A38 Derby Junctions

**8.28 Statement of Common Ground with
Breadsall Parish Council**

Statement of Common Ground
Breadsall Parish Council

Version	Date	Status of Version
Final	17 March 2020	Deadline 8 Submission

Inset E

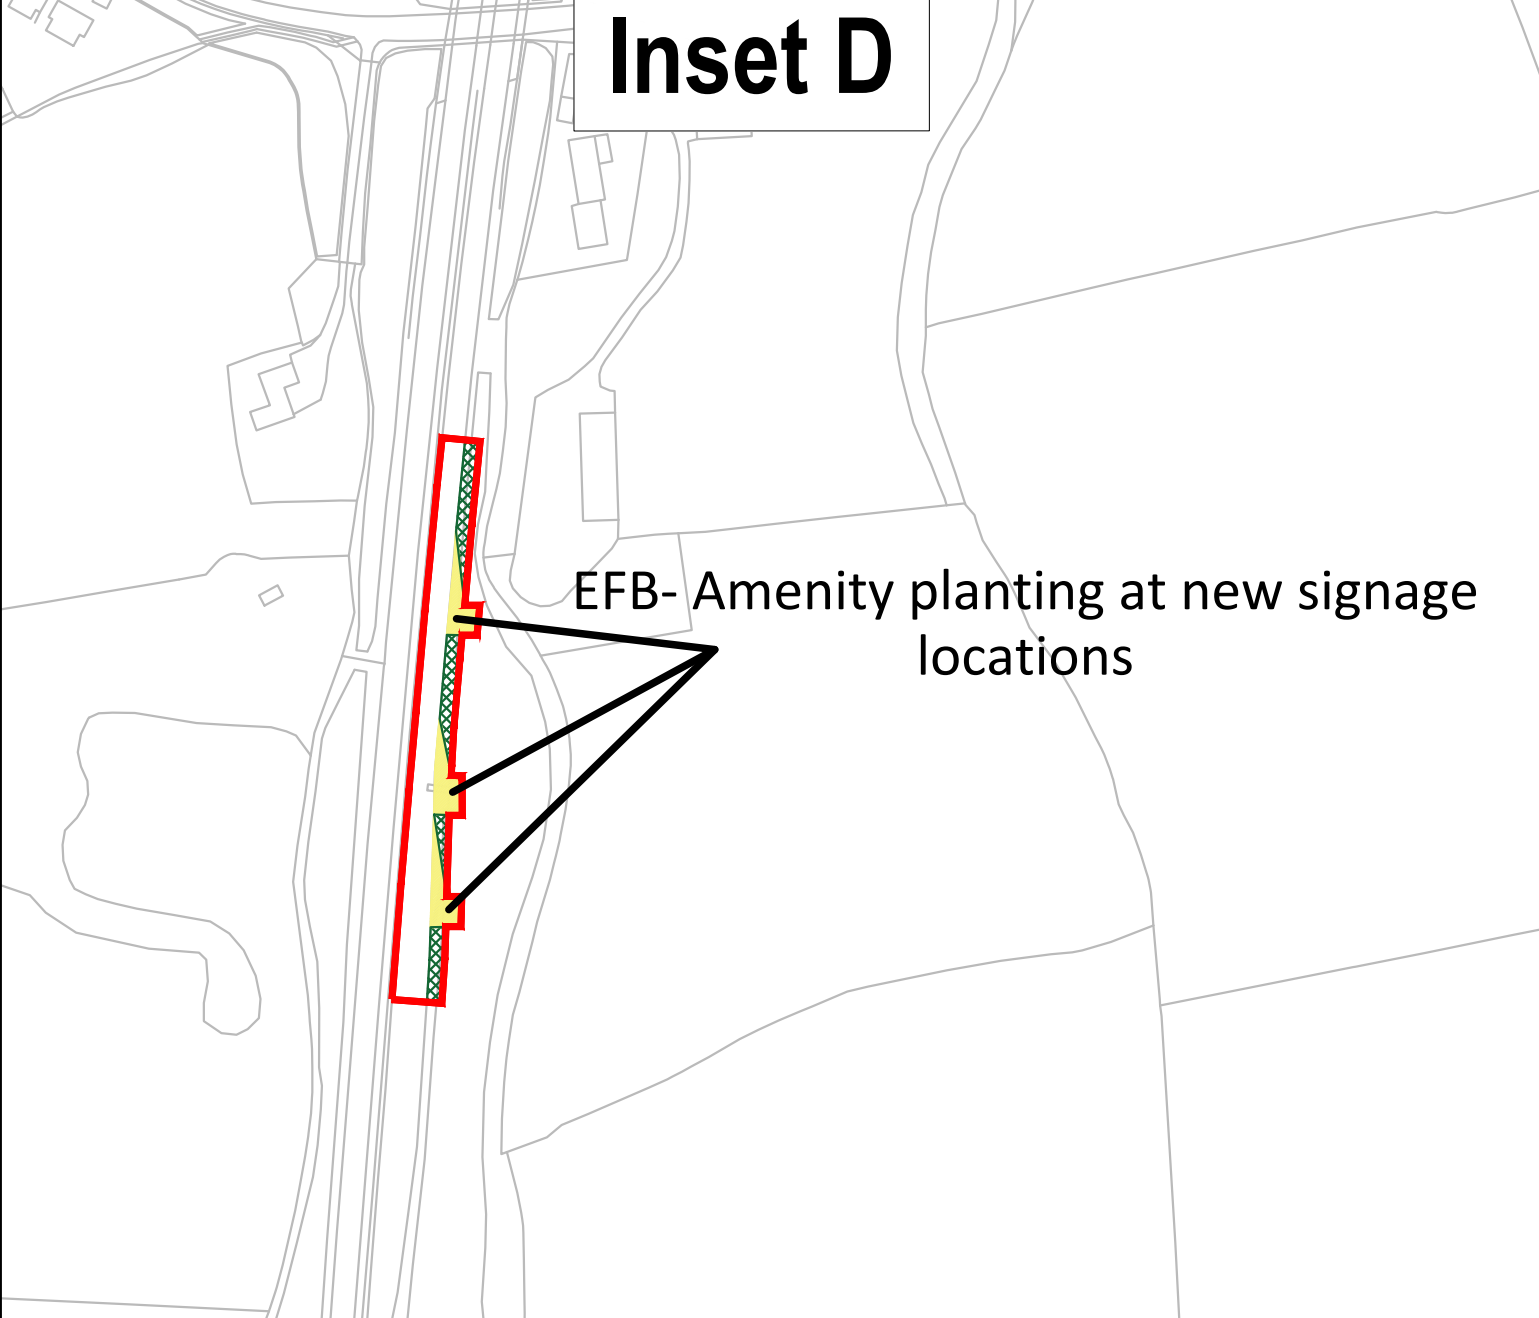
noise generation than a standard hot rolled asphalt surface. The use of low noise thin surfacing can reduce noise levels by 3.5dB at speeds of ≥ 75 km/hr.		
ES Chapter 9 – Noise and Vibration and Environmental Masterplans	[APP-047] [APP-068]	and	Noise and screening barriers at Little Eaton junction	BPC has highlighted that noise/ visual screening barriers at Little Eaton junction are essential. BPC would like to be consulted in relation to the detailed specification of the effectiveness, the durability and appearance of the barriers. BPC also require confirmation that the barriers would be suitably maintained.	In order to mitigate noise and visual effects, the Scheme design includes the following noise/ visual screening barriers: <ul style="list-style-type: none"> • 2.5m reflective noise/ screening barrier on the southbound diverge slip road to the A61 at Little Eaton junction. • 2.5m reflective/ absorptive noise/ screening barrier on the southbound A38 mainline at Little Eaton junction. • 2.5m reflective noise/ screening barrier on the northbound A38 mainline at Little Eaton in the vicinity of the Ford Farm Mobile Home Park. Such barriers are illustrated on the Environmental Masterplan ES Figures 2.12F and 2.12G [APP-068] . The two Highways England responses below are also of relevance to BPC's comment.	Agreed
